Re: Desert Sands Subdivision Preliminary Plat, DRB# 1005224

Attached please find a revised Infrastructure List, Preliminary Plat, Grading Plan, and Sidewalk Exhibit incorporating revisions to address the comments received at DRB on Feb 17, 2016. The comments have been addressed as described below in red.

PRELIMINARY PLAT  
 DESERT SANDS SUBDIVISION  
 WITHIN THE  
 TOWN OF ATRISCO GRANT  
 PROJECTED SECTION 4  
 TOWNSHIP 9 NORTH, RANGE 2 EAST, NMPM  
 CITY OF ALBUQUERQUE  
 BERNALILLO COUNTY, NEW MEXICO  
 JULY, 2016

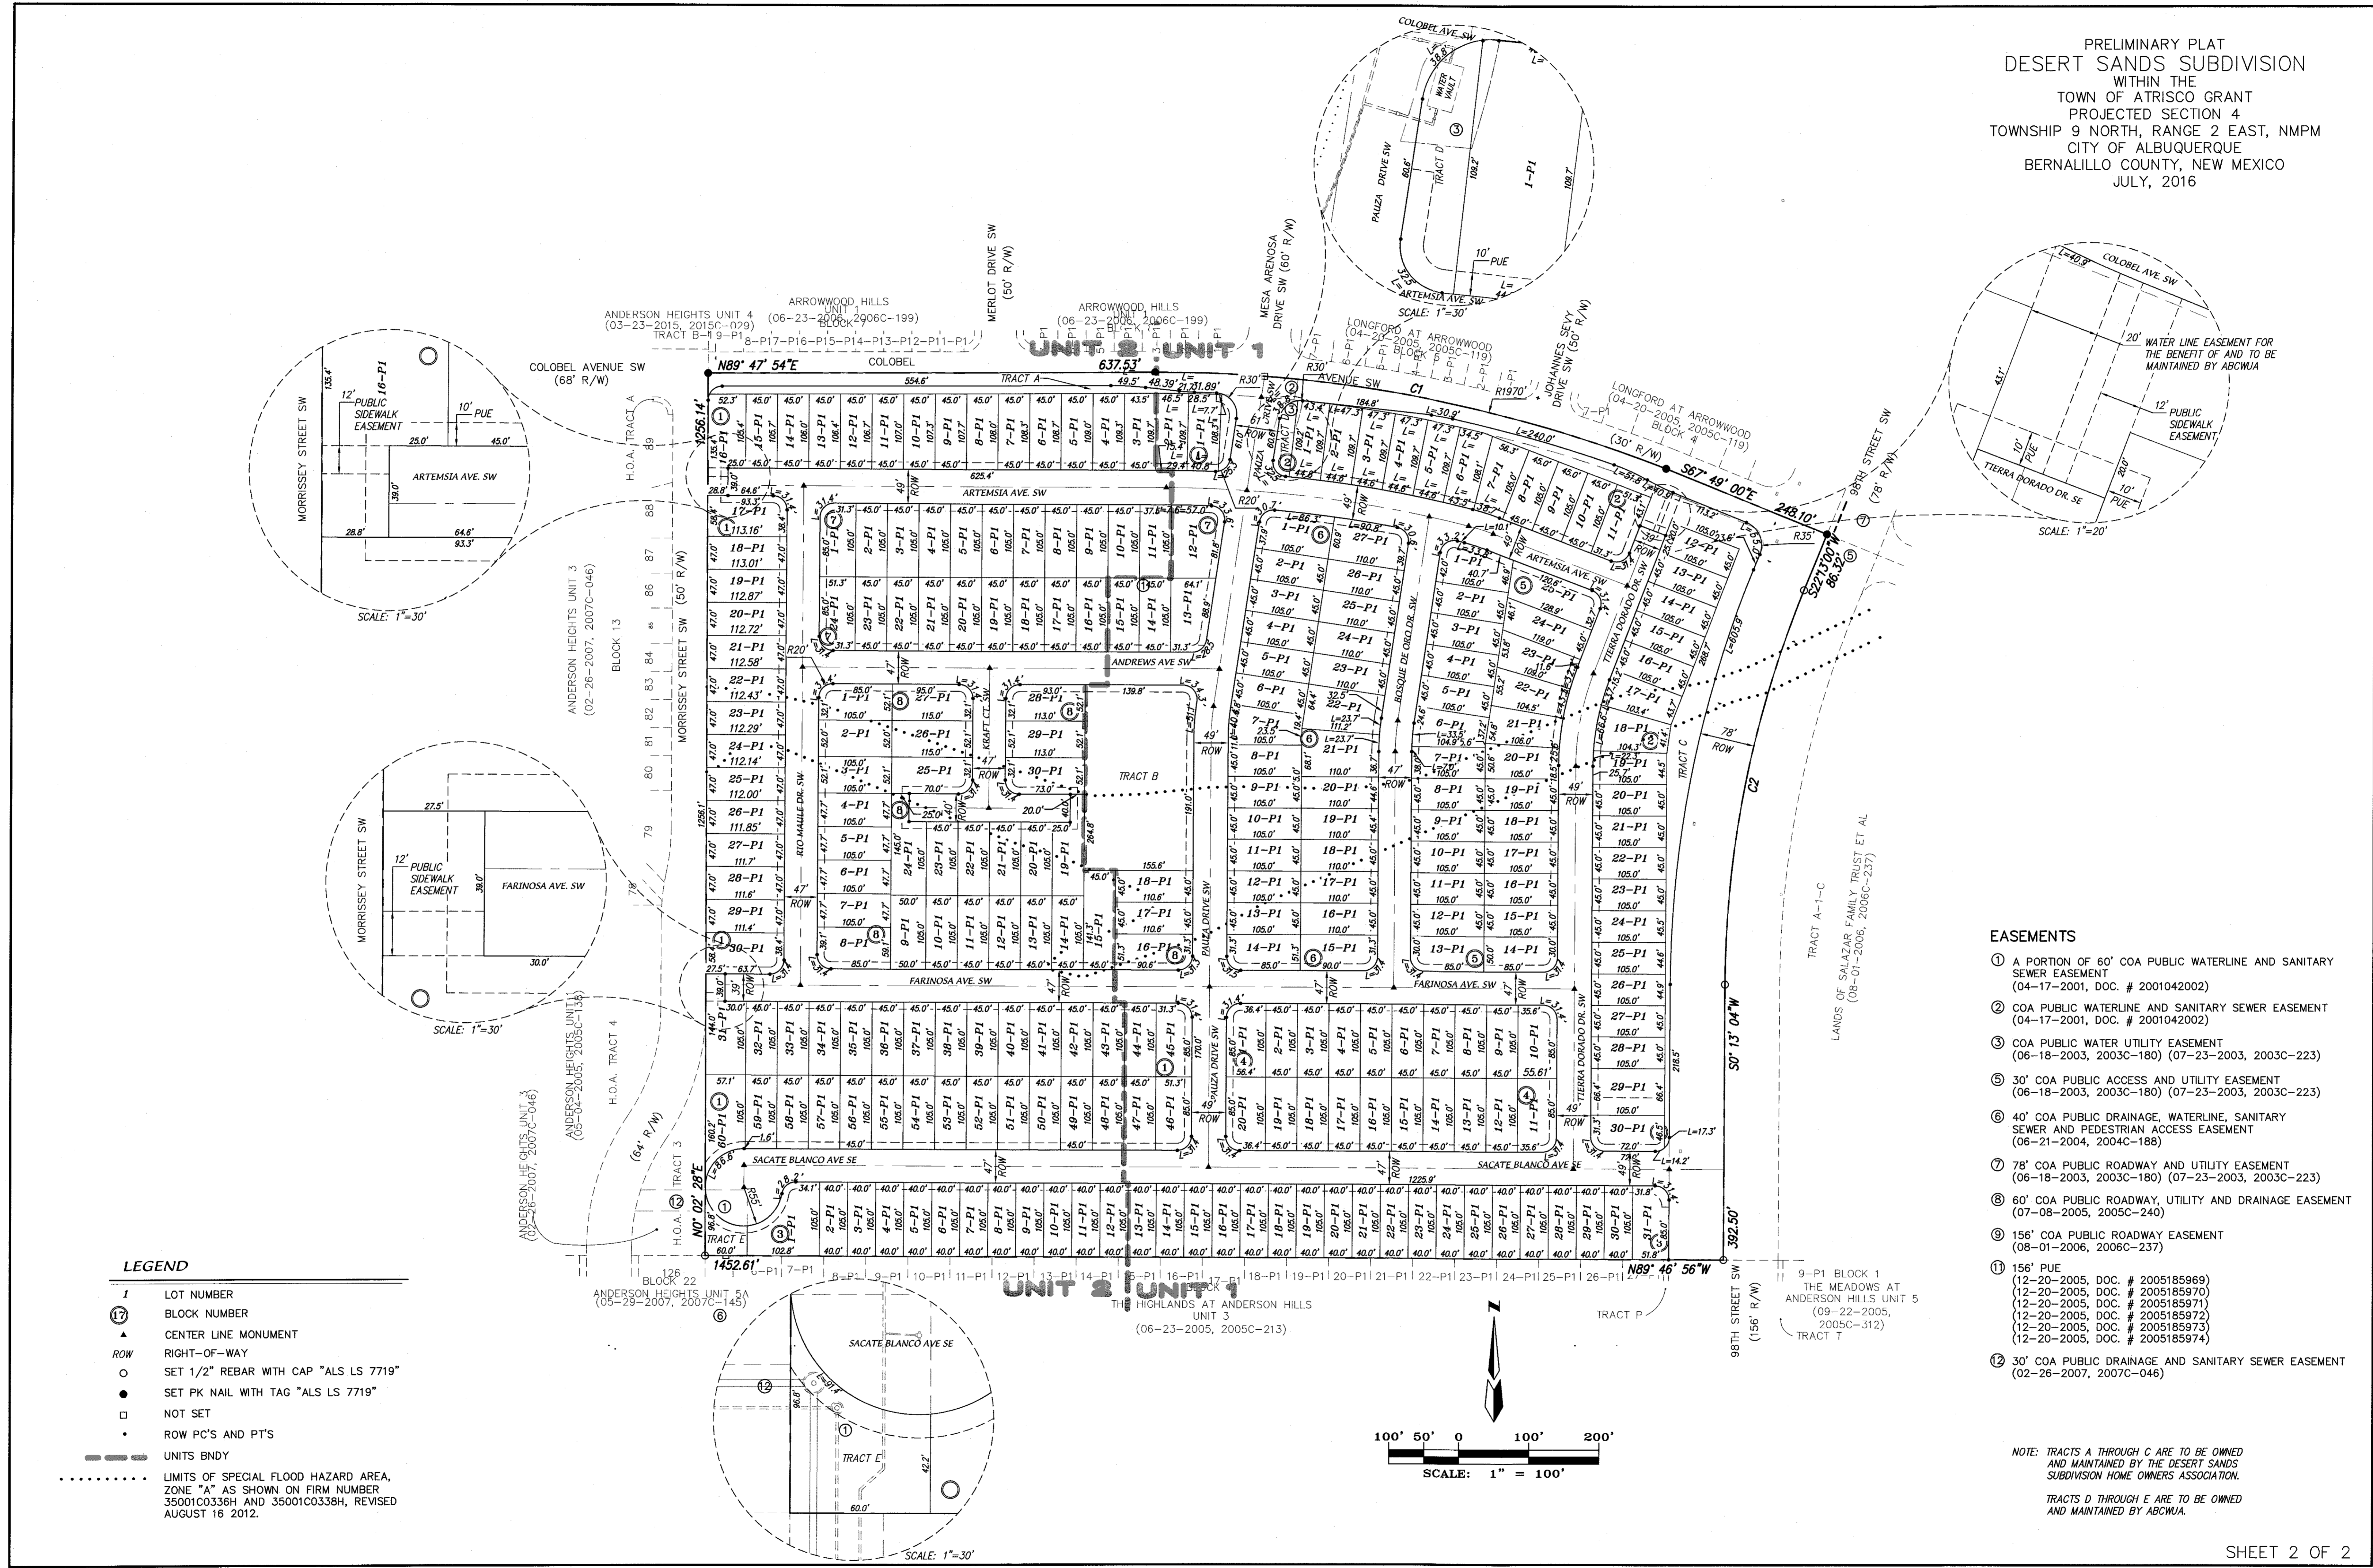
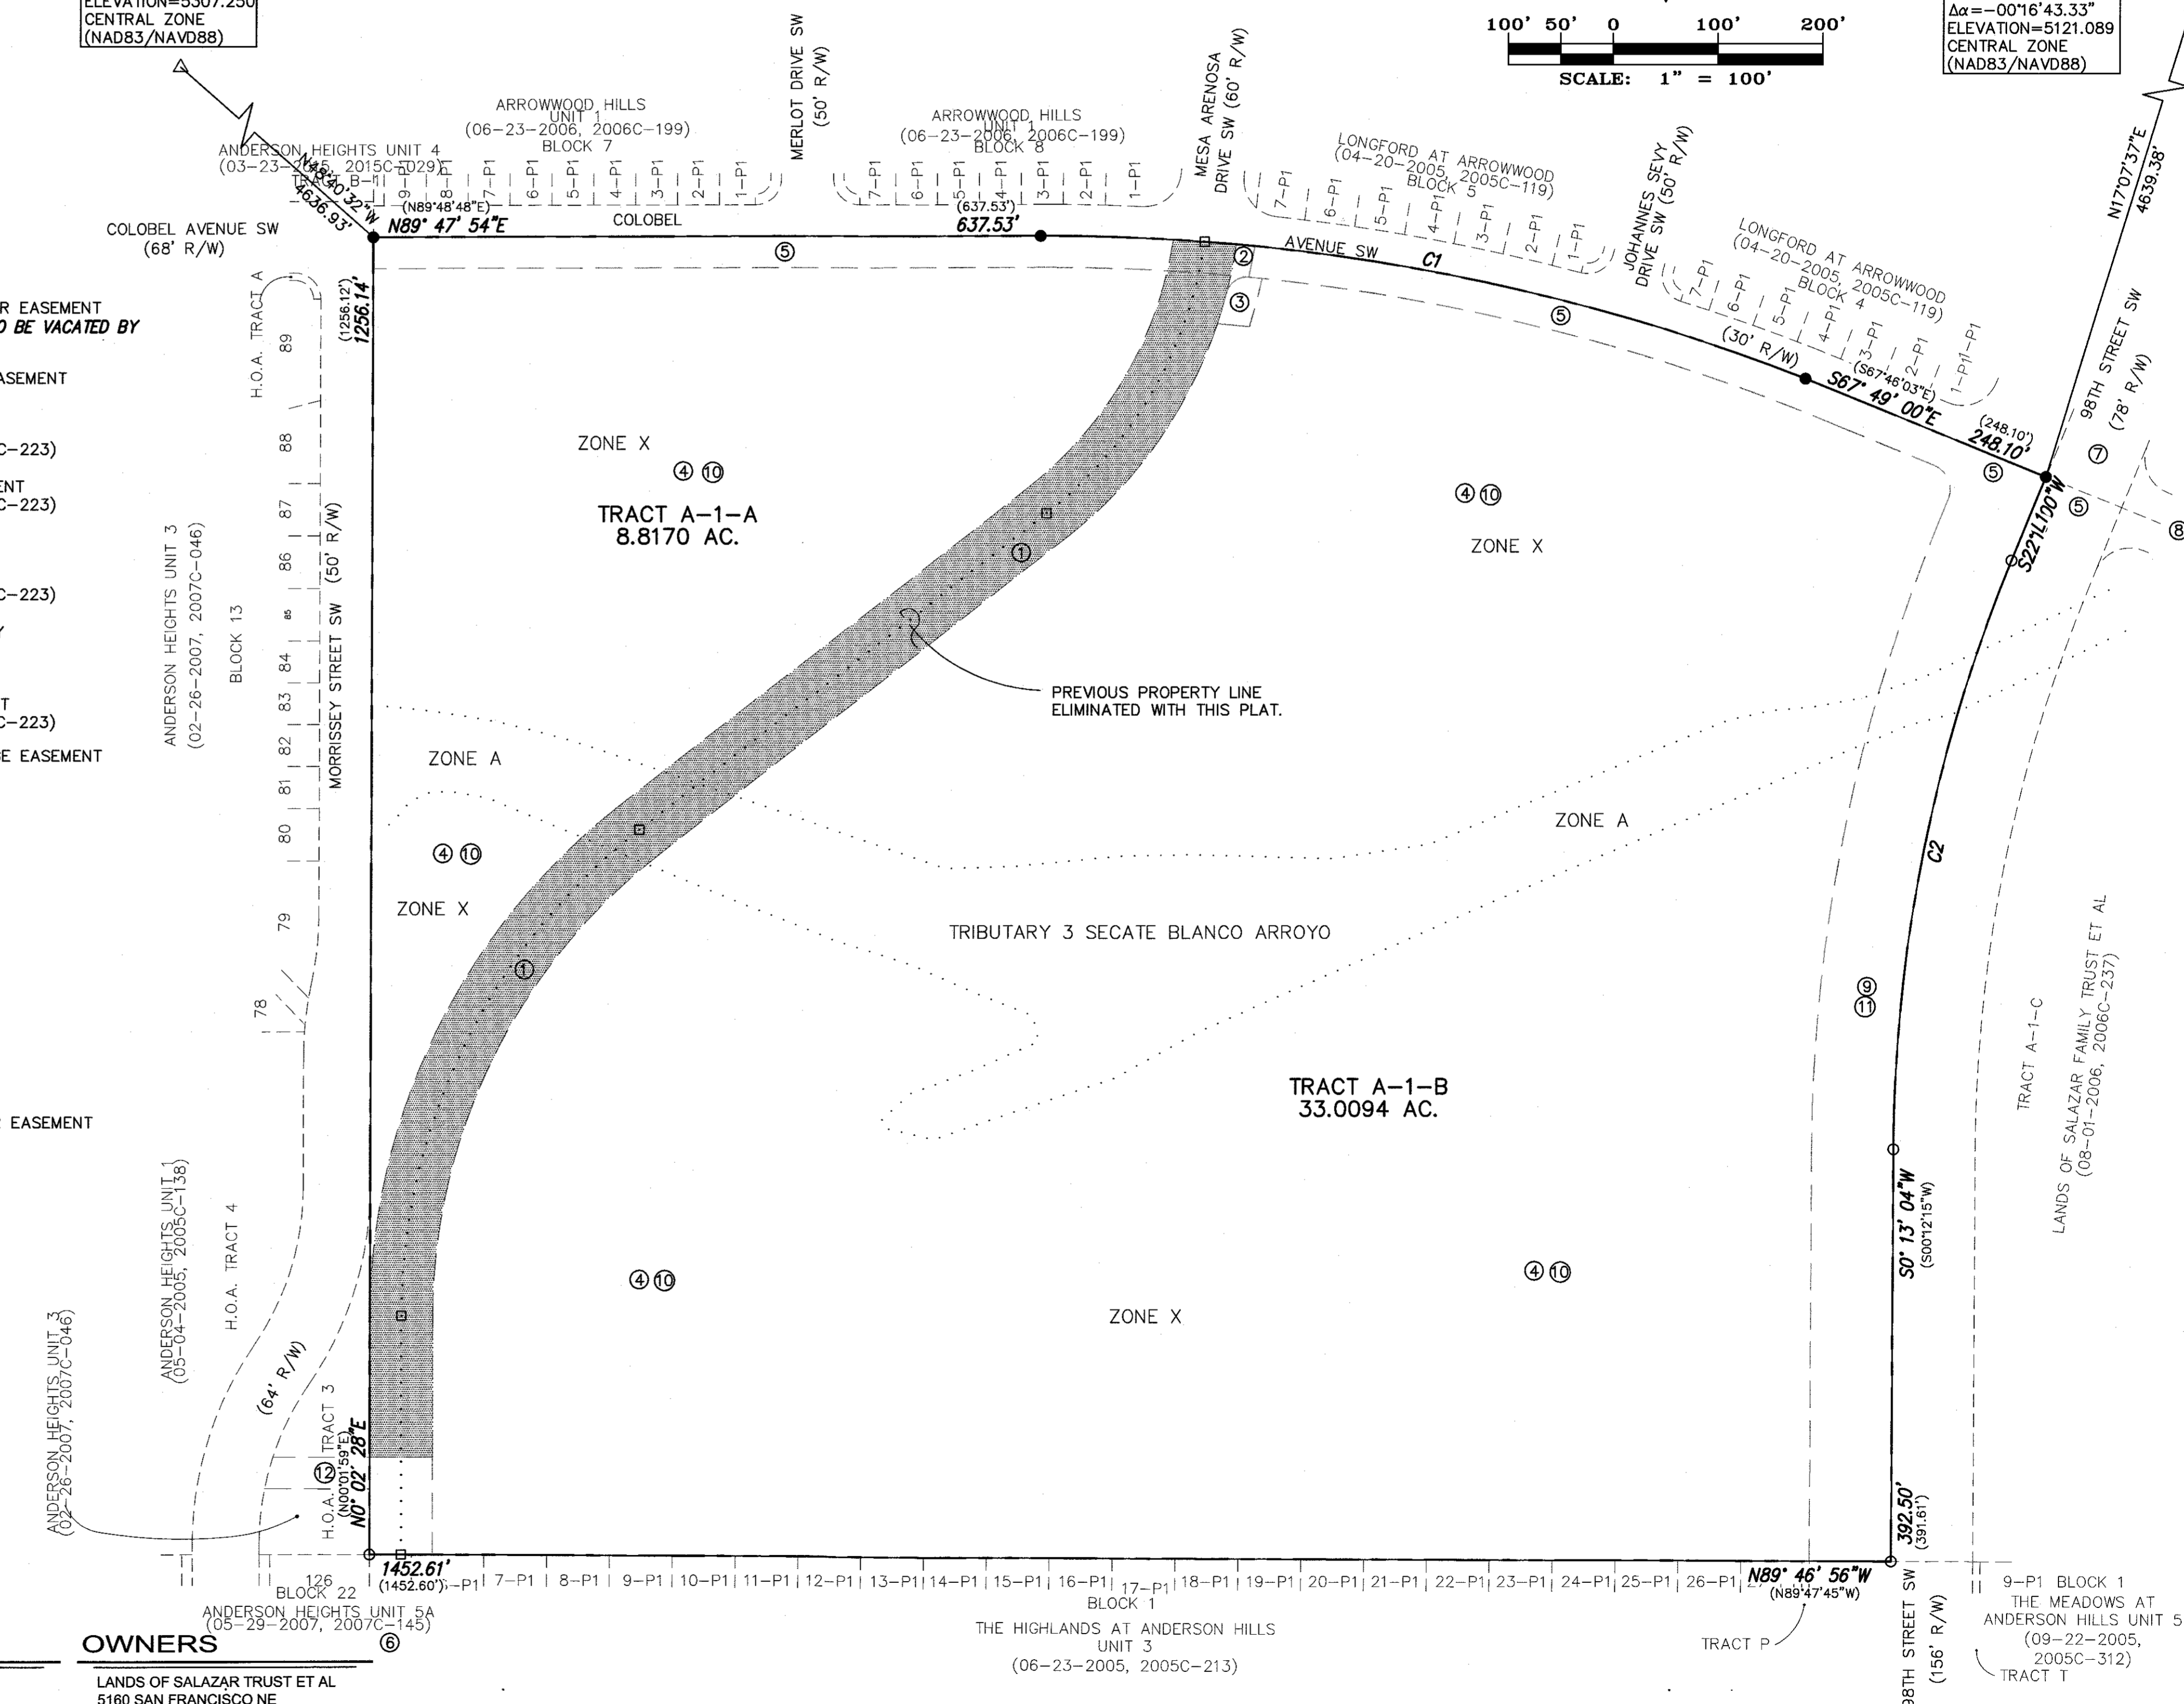
- 7 The pavement width of the Tierra Dorado Stub north of Artemsia St has been changed on page 2 of the Infrastructure List.
- 8 The Right of way width label for Artemsia Ave. west of Pauza Dr. has been changed from 47' to 49' on the Preliminary plat.

Additional pedestrian connections have been added to sheets 1,2,and 4 of the Grading and Drainage Plan and to pages 3 and 6 of the Infrastructure list. Pedestrian easements have been added on the Preliminary Plat.
